Subject: FW: Reference planning application number PP-08589020

REP FOR BR/75/20/HH

With reference to the Planning Application PP-08589020 for 140 London Road, Bognor Regis, I notice it includes a roof level glass terrace which extends over the back wall of the building.

PROPOSED PLANS AND ELEVATIONS

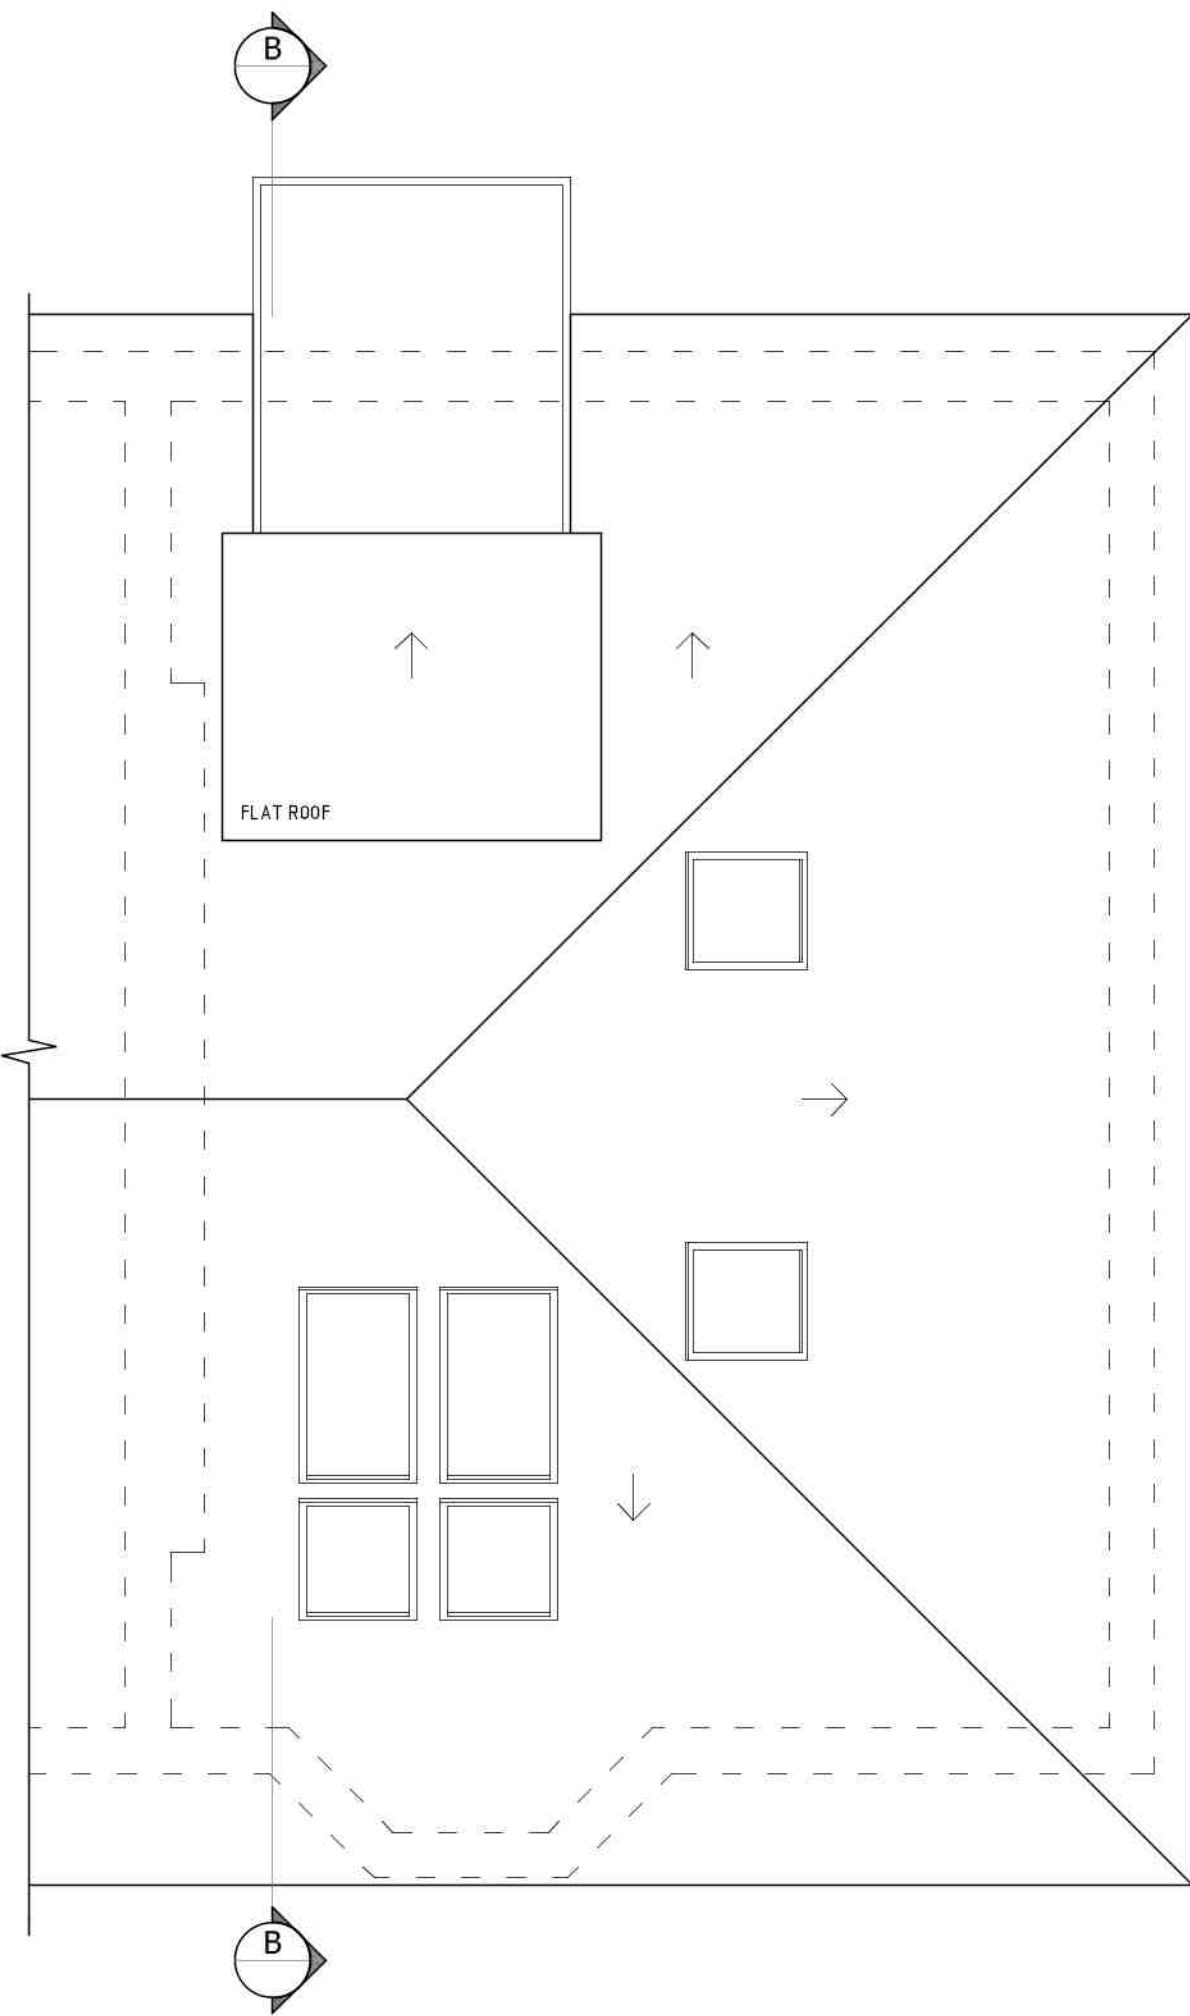
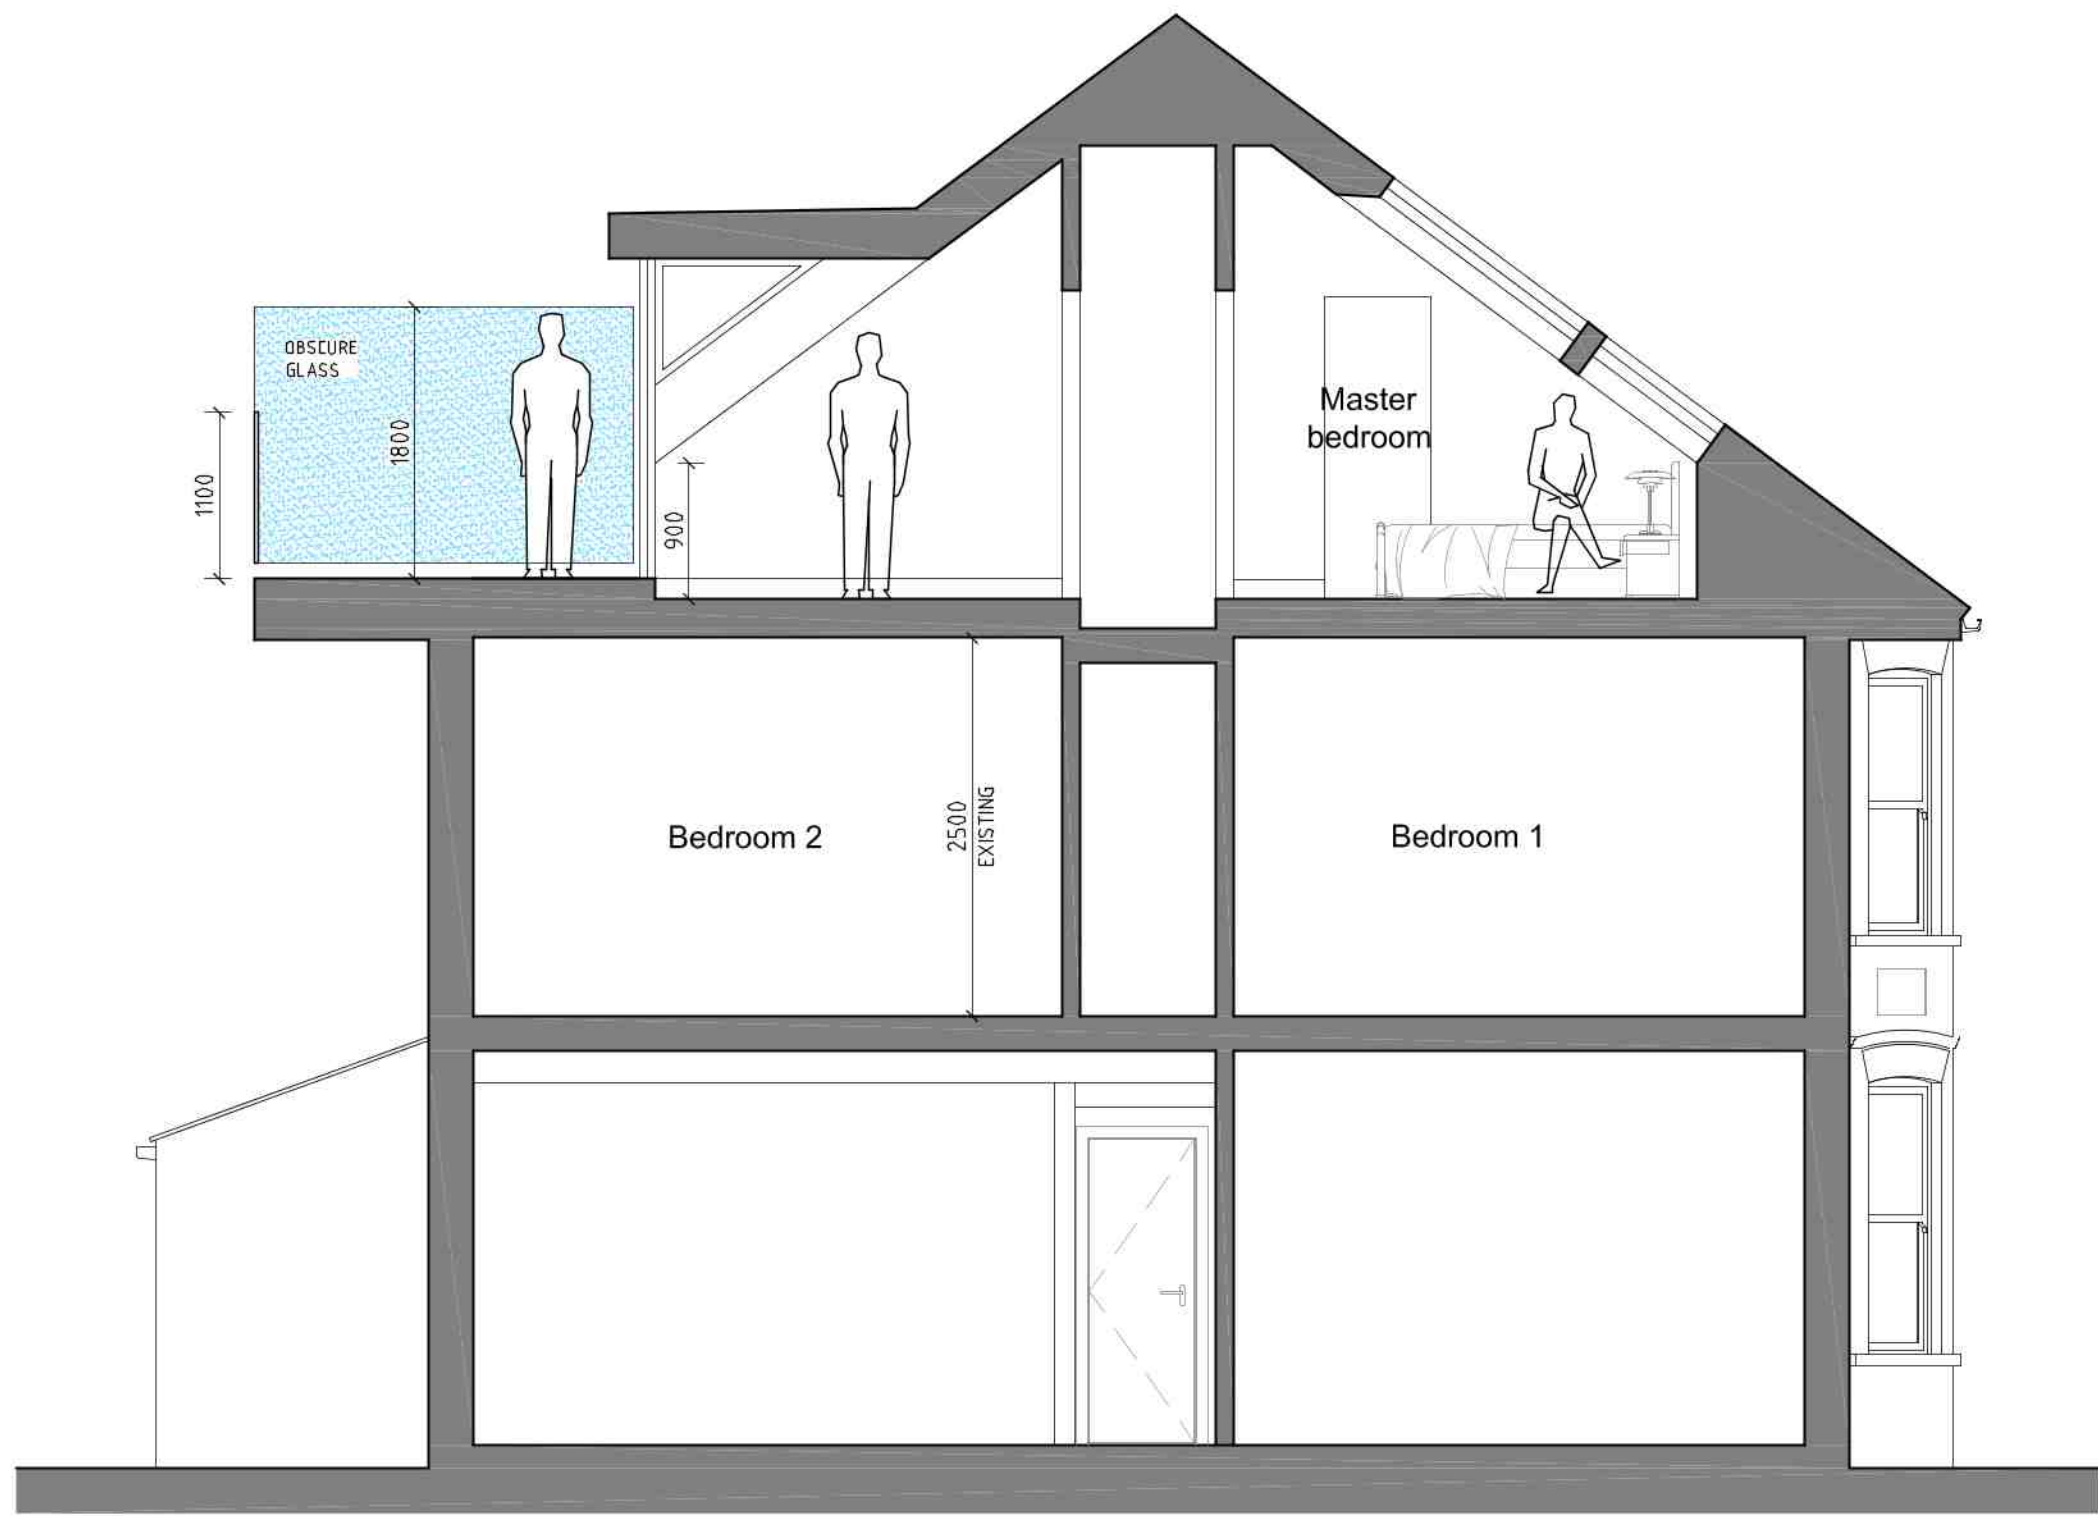
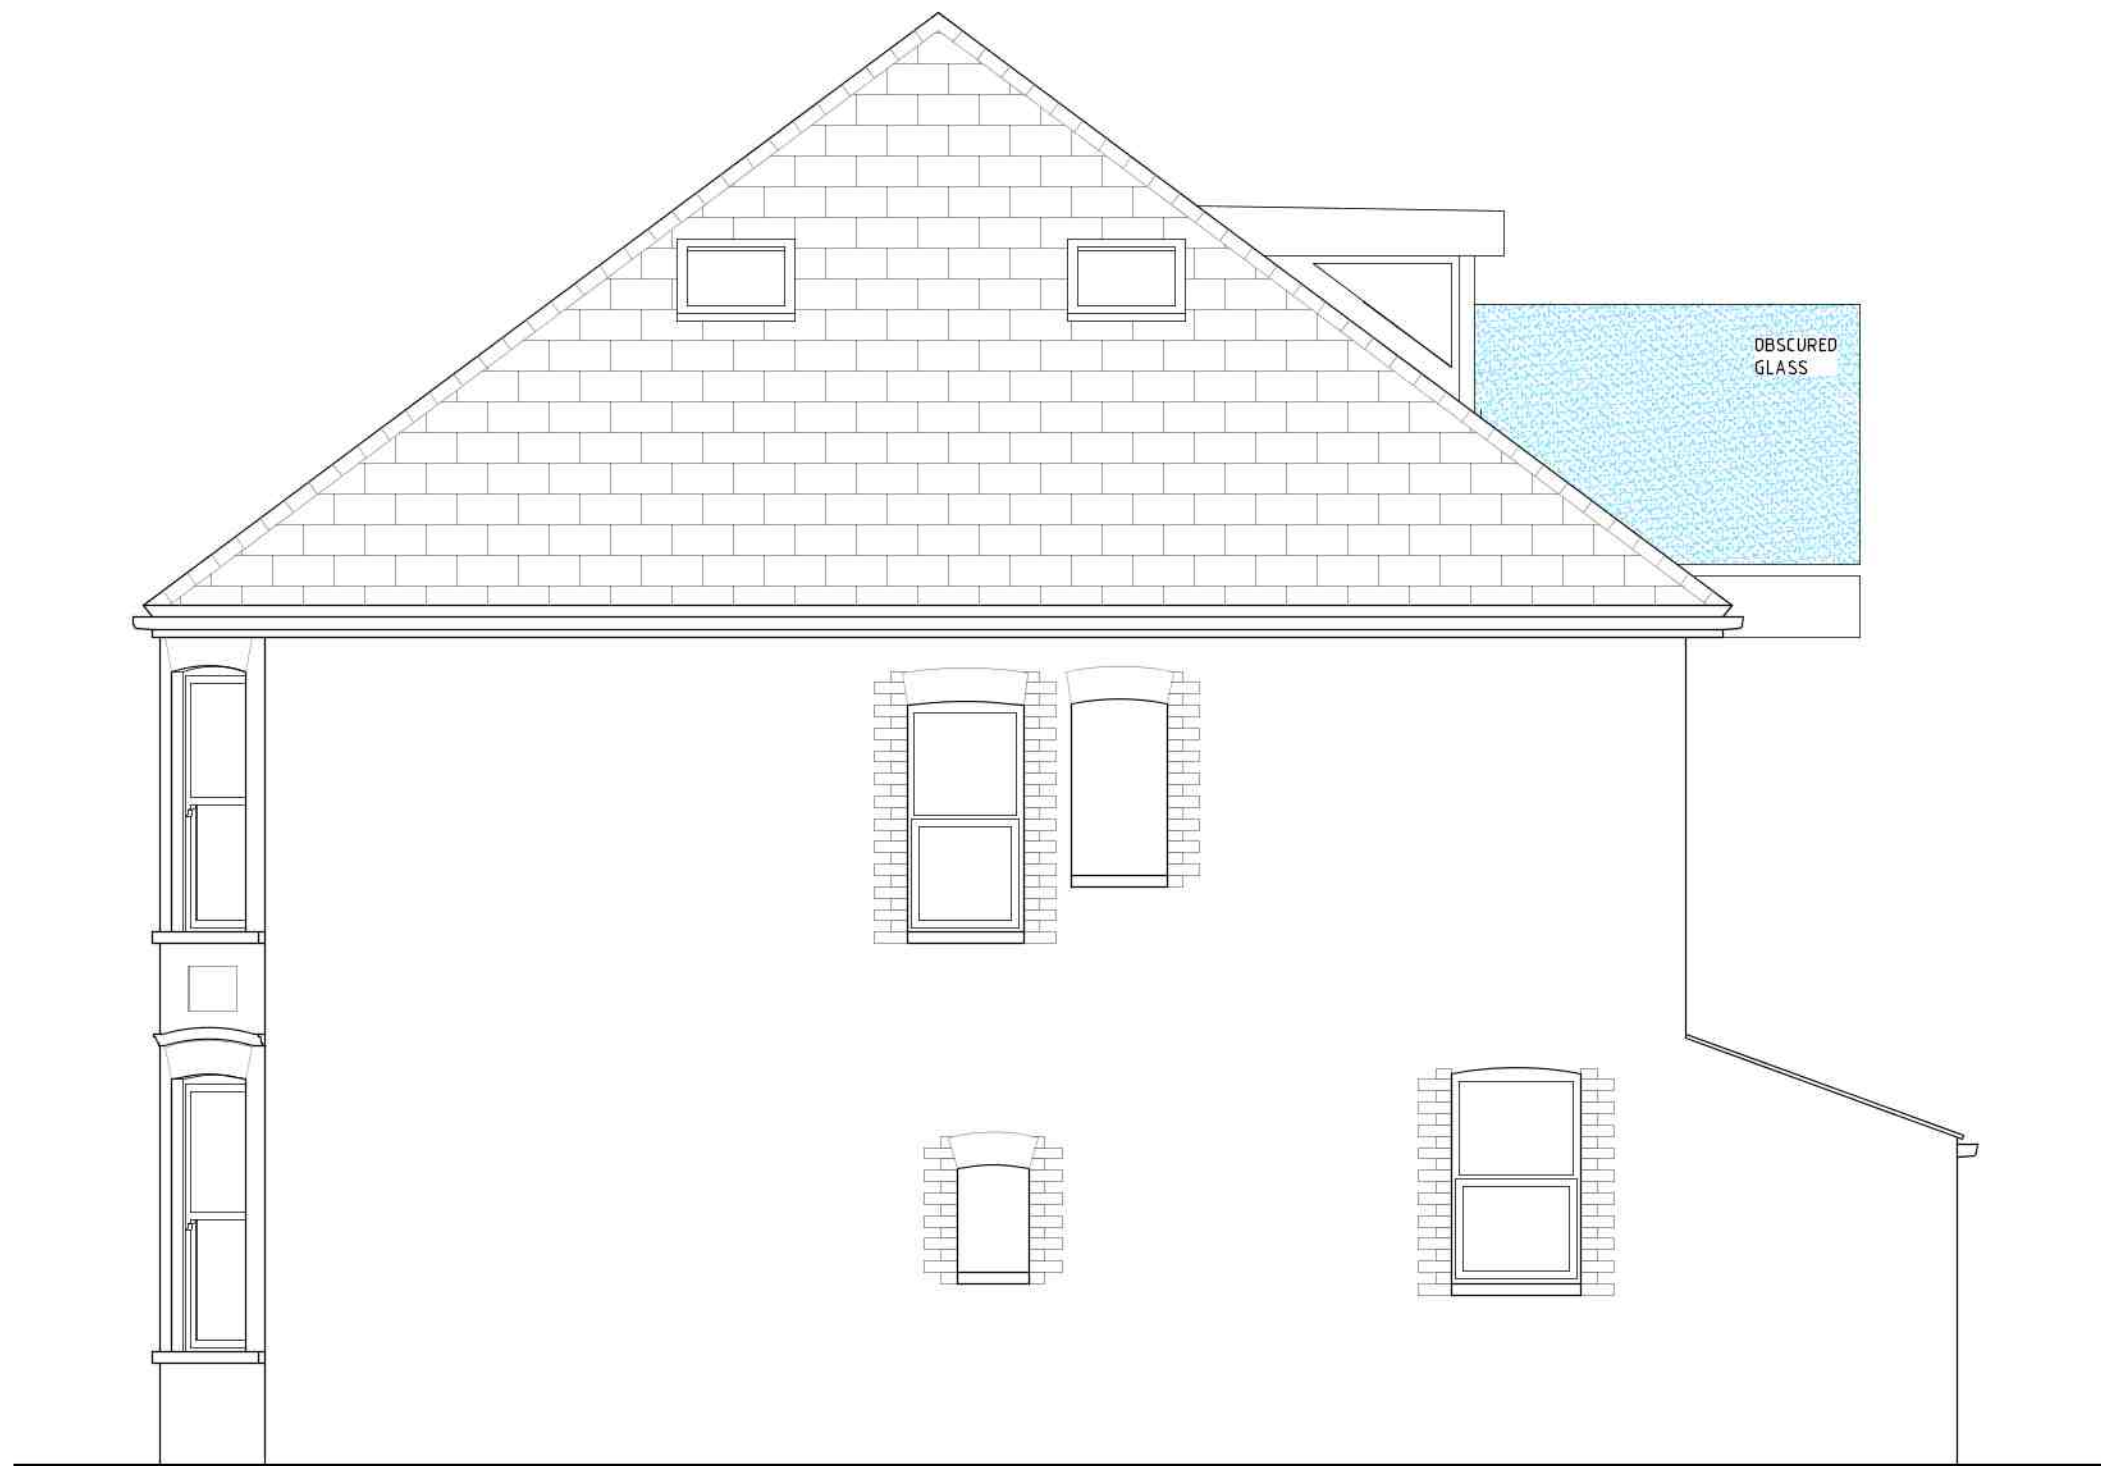
This would provide an unobstructed view directly into the back gardens of the adjacent properties on both sides and possibly those to the rear.

I object to this application on behalf of those neighbouring properties in that it compromises their privacy.
